CITY OF ALBUQUERQUE

June 15, 2022

**RE: Homes Direct
601 San Jose Ave. SE
Grading & Drainage Plan
Engineer's Stamp Date: 05/06/22
Hydrology File: M14D004E**

Site Details

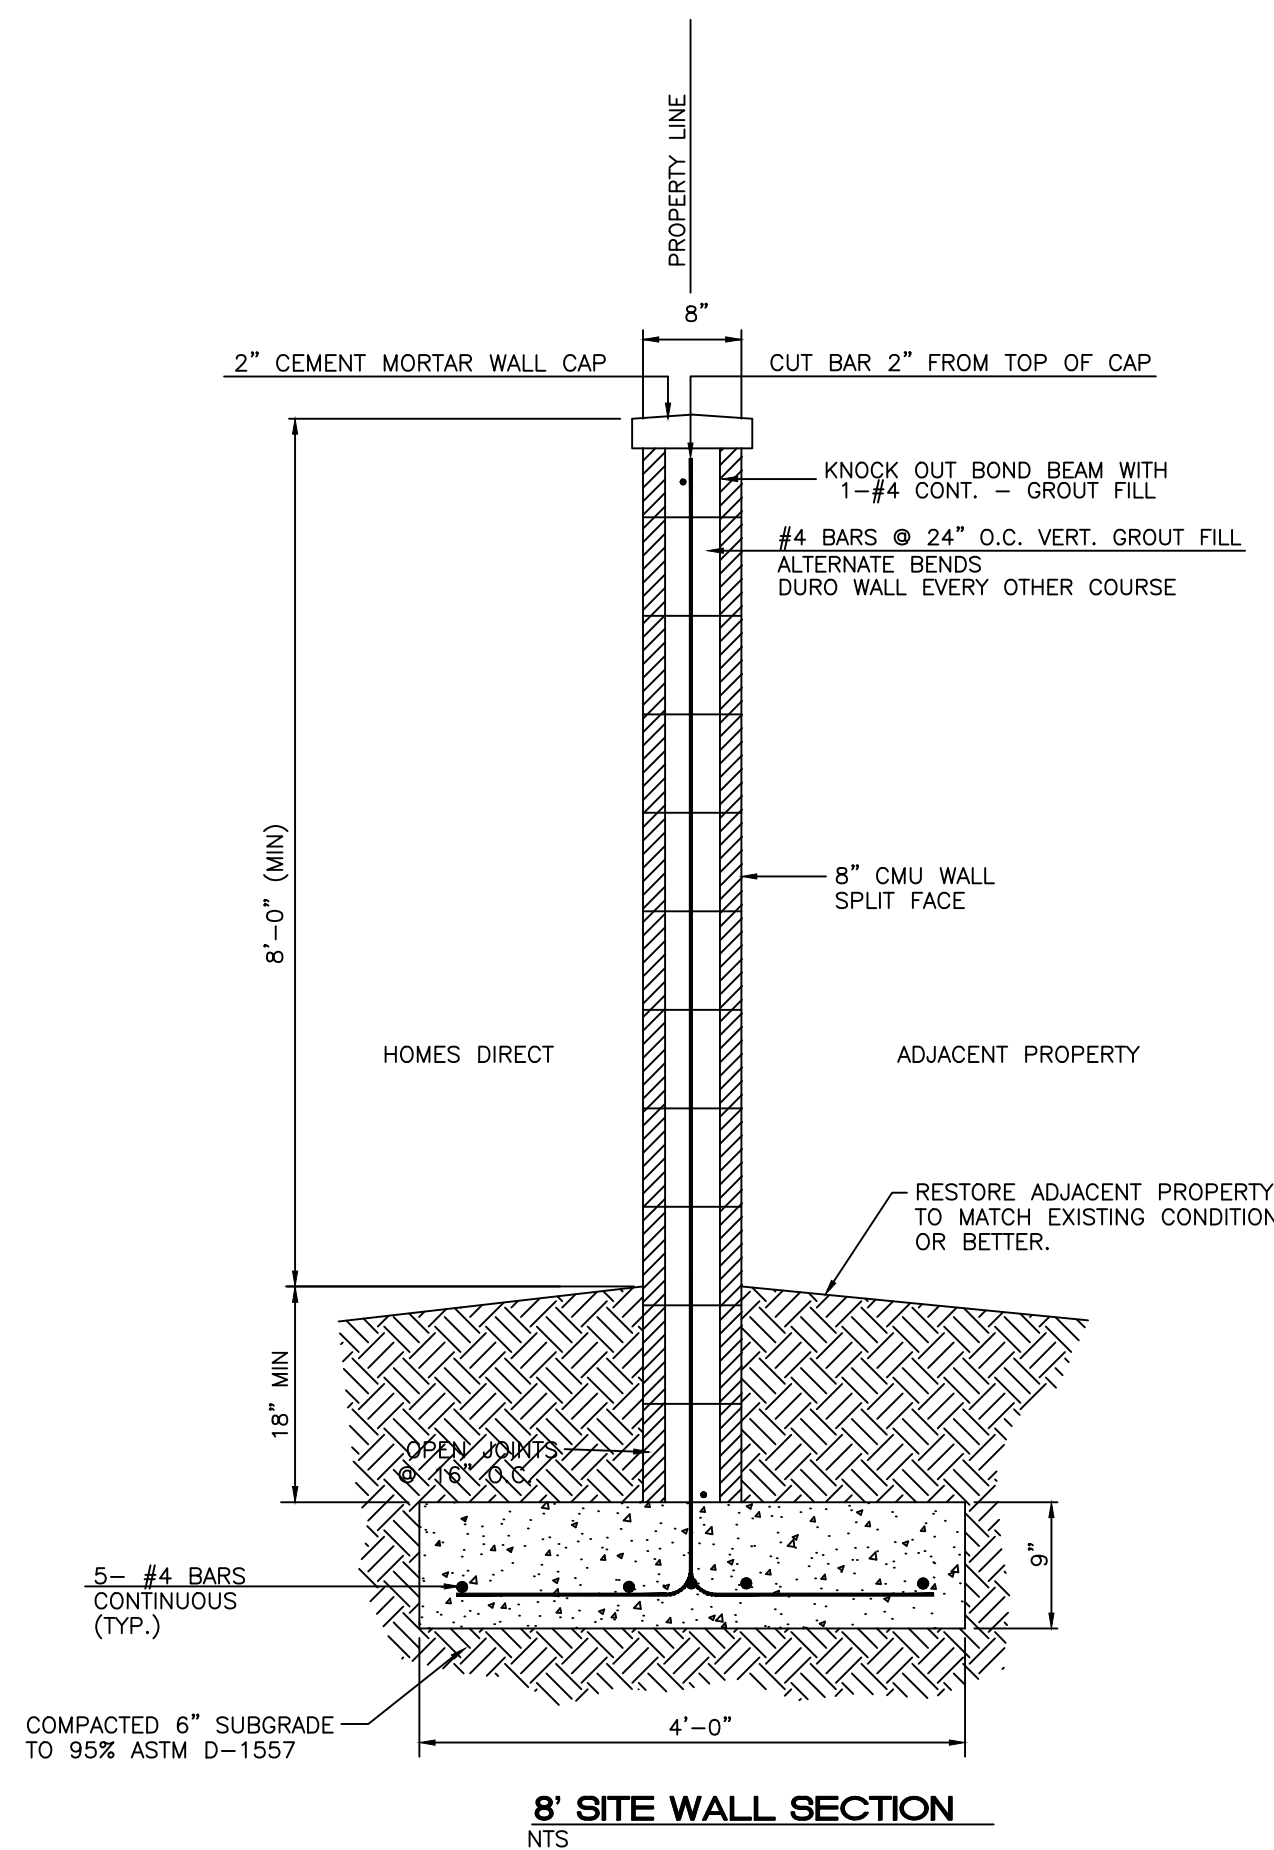
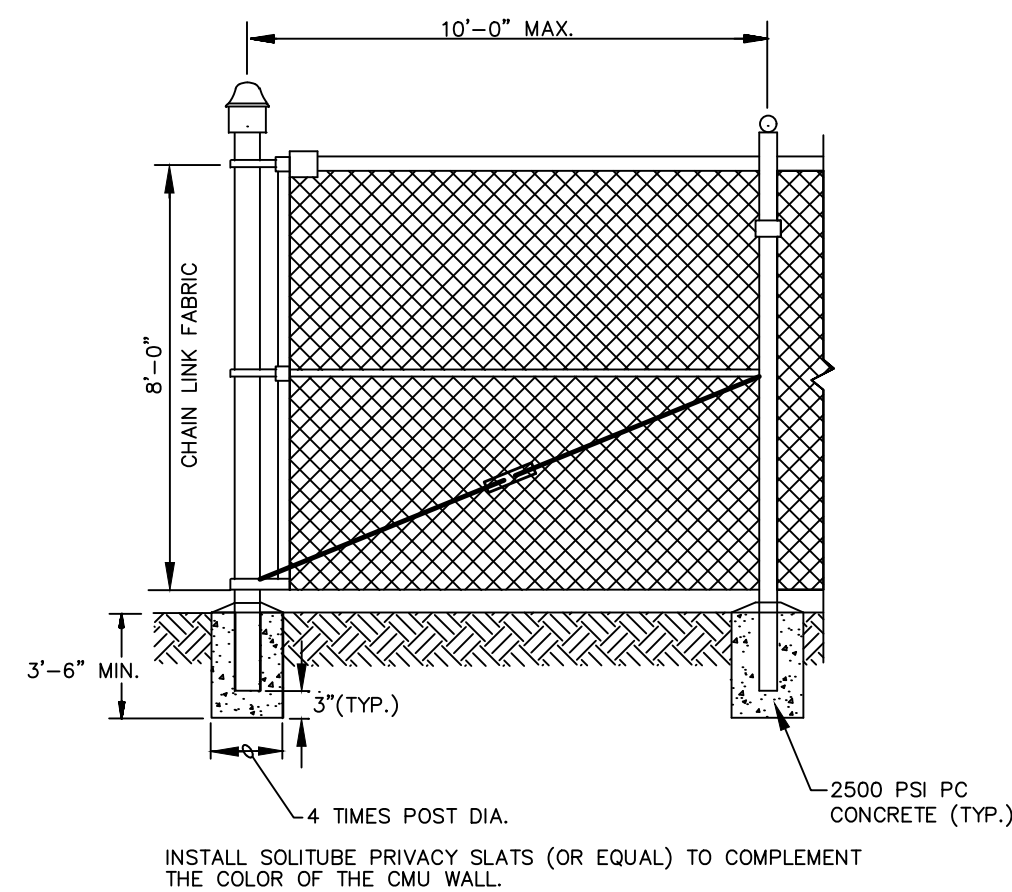
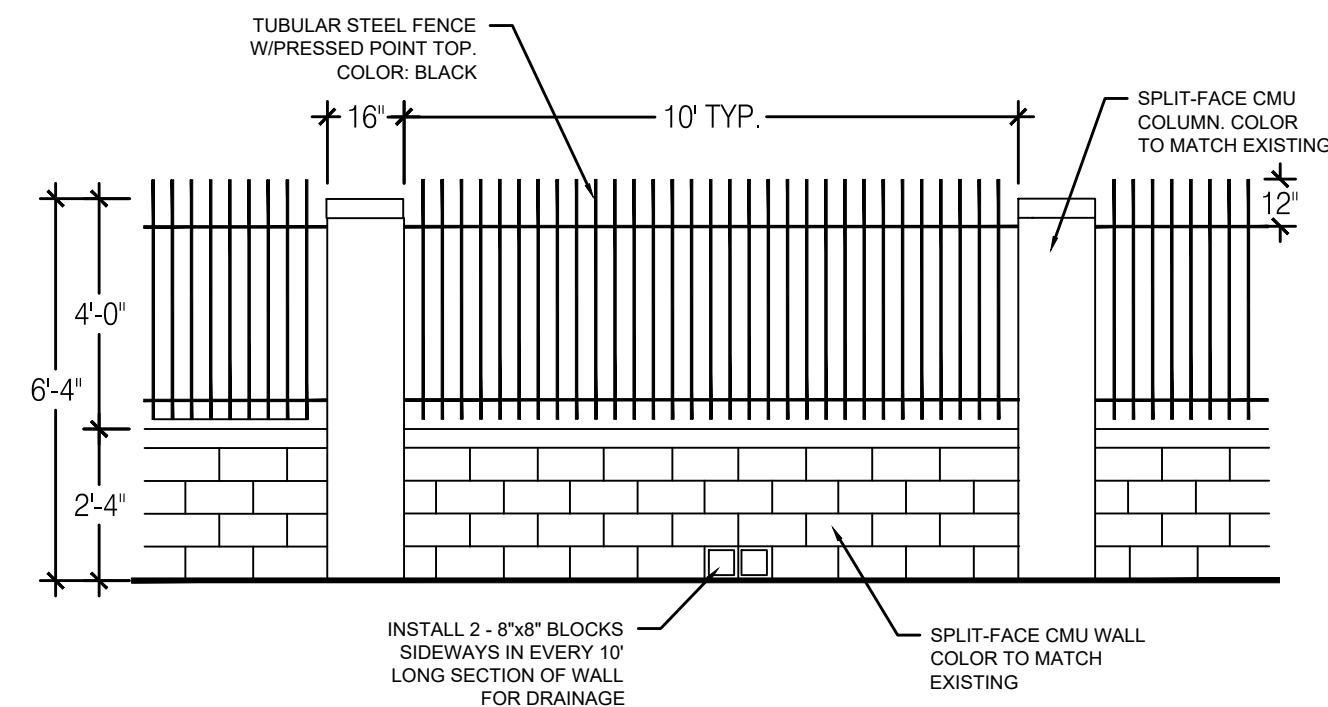
3. Please provide the top of wall, existing and proposed grades on both sides of the proposed garden wall. Also, please provide sections through all external boundaries showing proposed garden walls, type of footer, property/ROW lines, existing and proposed grades.
